MEMORANDUM

DATE:	February 12, 2021	RWDI REFERENCE #: 1904405
TO:	Anthony Witherdin	Director, Key Sites Assessments - DPIE
FROM:	Kevin Peddie	Email: kevin.peddie@rwdi.com
	Michael Pieterse	michael.pieterse@rwdi.com
RE:	ADG Natural Cross Ventilation- City of Sydney Review Response Waterloo Metro Quarter – Building 4

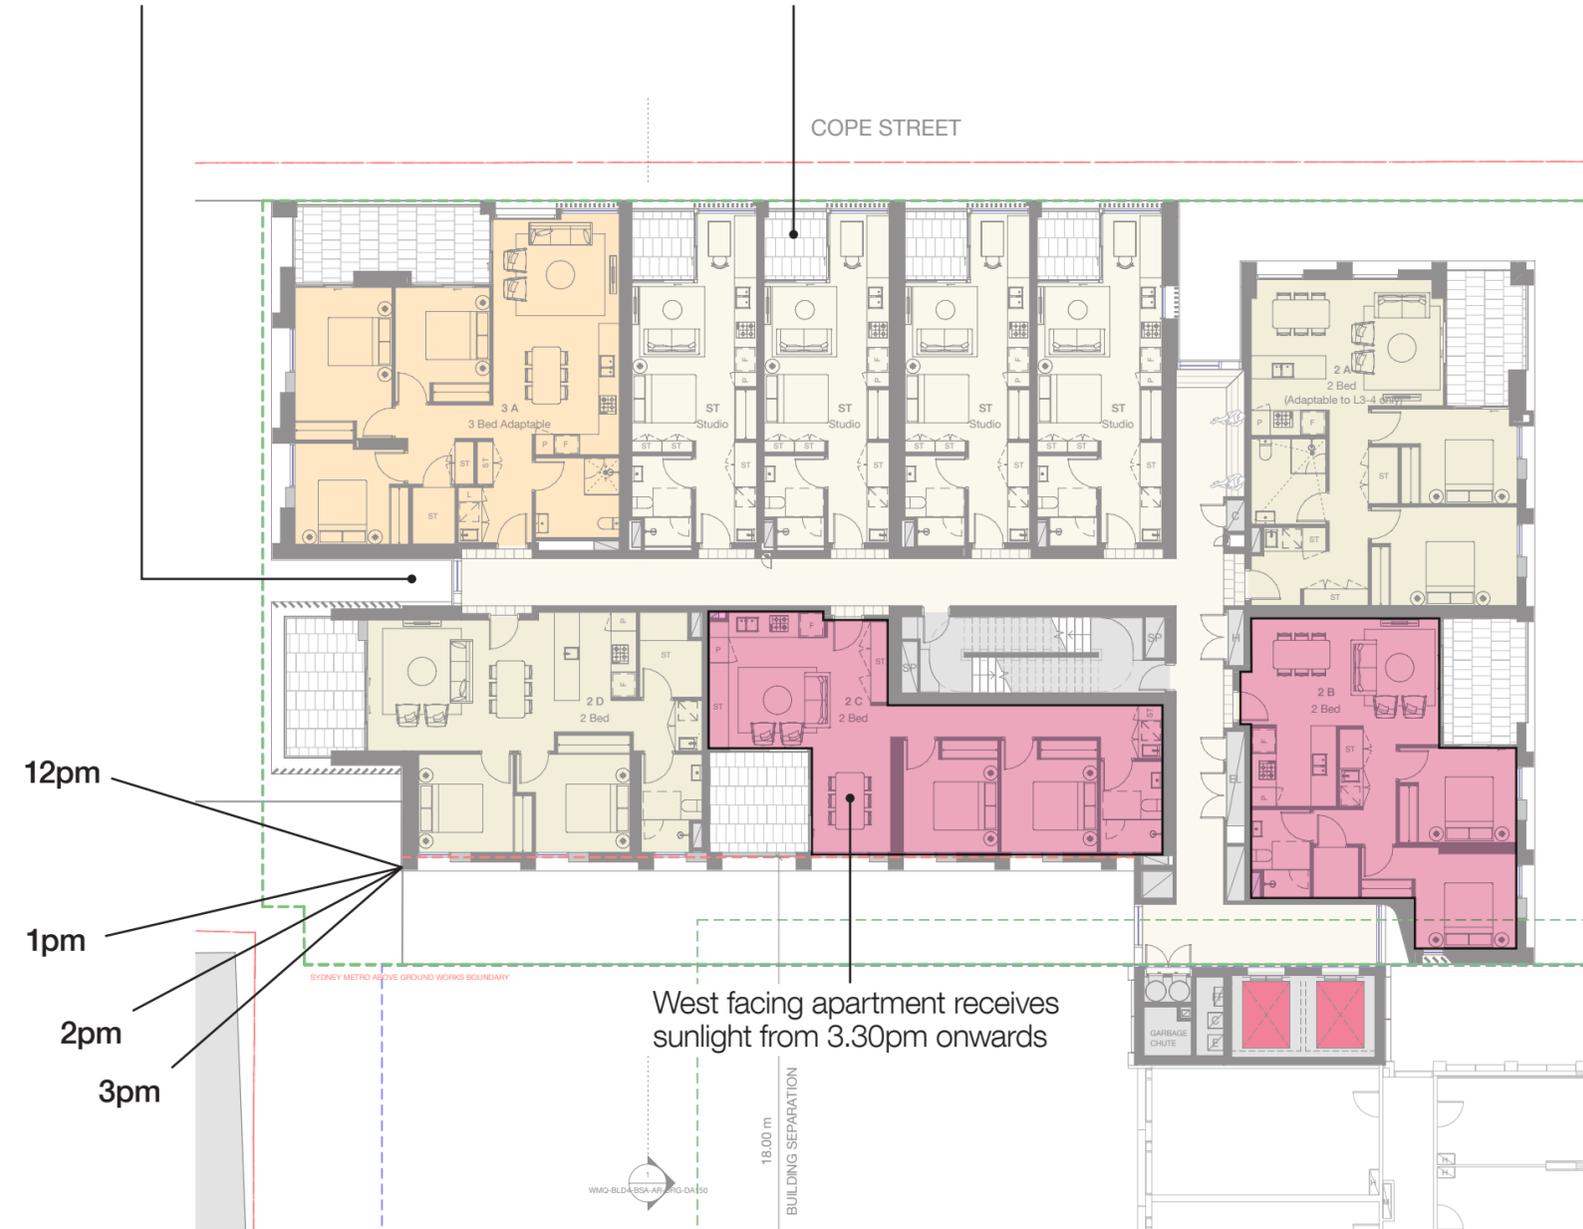
Item 28 - Natural cross ventilation -The application erroneously claims that 60% of apartments are designed to achieve natural cross ventilation, however only 34% of apartments meet the definition of naturally cross ventilated. For example:

- *Plenums must not be used to claim natural cross ventilation as they do not provide equal sized outlets for pressure-based airflows.*
- *Corner apartments that do not have opposite openings of equal size and do not provide a logical flow path of air should not be counted.*
- *Natural ventilation paths should not cross common circulation spaces.*

The apartments considered to be naturally cross ventilated in accordance with the Apartment Design Guide for the Building 4 design. The tower design includes a setback to the south-eastern corner apartment on the eastern aspect to create a stepped form and enable exposure to the prevailing winds in accordance with the ADG requirements for Natural Cross Ventilation.

As noted in the Response to Submission document prepared by the project architect, Building 4 was required to balance a number of aspects including the apartment mix brief from the LAHC, maximising the solar access to the residential apartments and minimising apartments with no access to sunlight. The floor plan layout was also limited by its location atop the metro station services box, the need to naturally ventilate the corridor space while also considering apartment entrance door operability issues due to pressure differential between the corridor and apartment window openings.
